**WELWYN HATFIELD BOROUGH COUNCIL
ASSISTANT DIRECTOR (PLANNING)**

DELEGATED APPLICATION

Application No: 6/2023/0374/FULL
Location: 11 Tolmers Gardens, Cuffley, Potters Bar, EN6 4JE
Proposal: Conversion and extension to existing dwelling to create four self-contained units with associated infrastructure
Officer: Ms Kirsty Shirley
Recommendation: Refused

PROPOSED STREETSCAPE ON
TOLMERS GARDENS

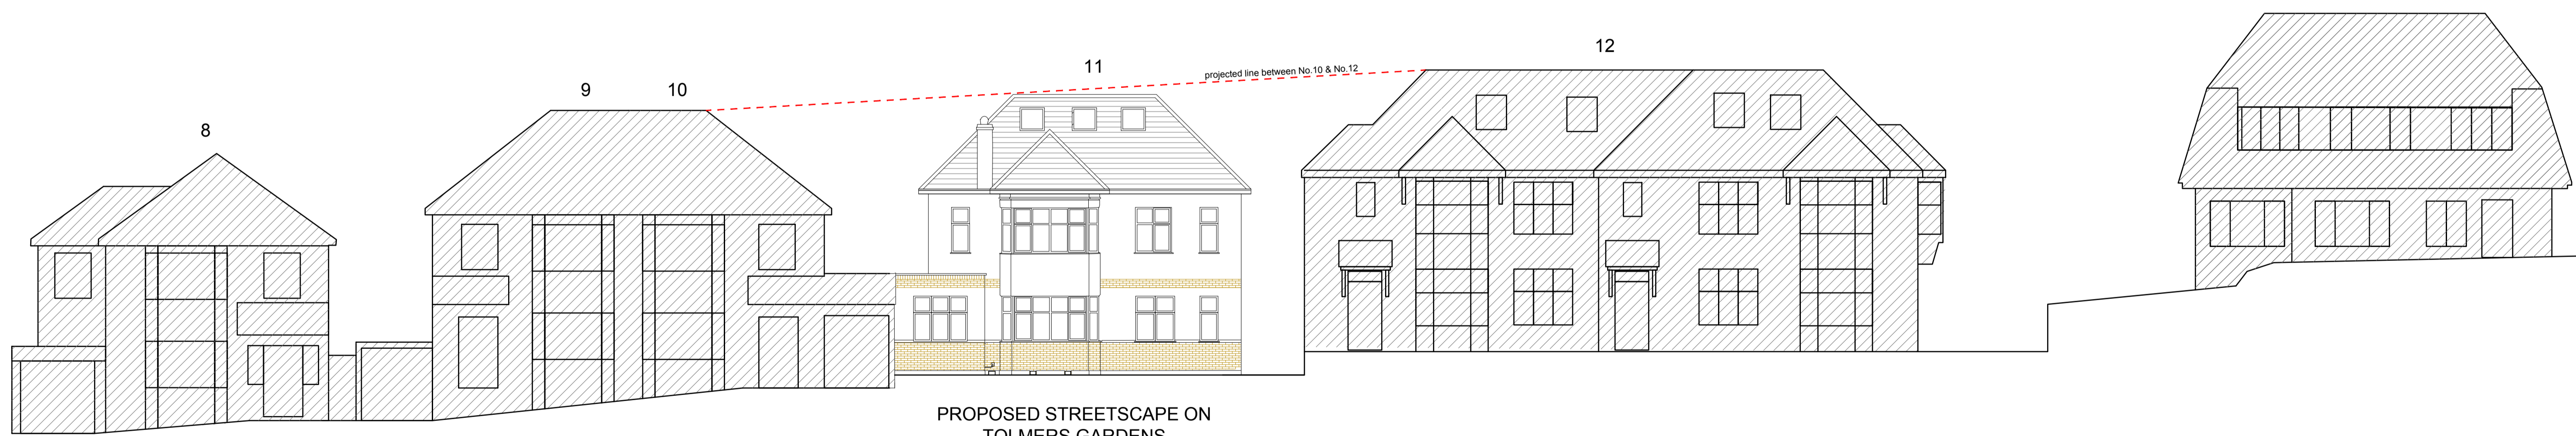
The proposed extensions and enlargements would result in a substantially larger building on the site. It is however noted that the application site has a greater area than the existing curtilage of No.11. The eaves and ridge height of the resultant development would adequately respect the stepped building heights of neighbouring properties on its row, there would be sufficient set-in distance at first floor level and above, and the existing building line would be maintained.
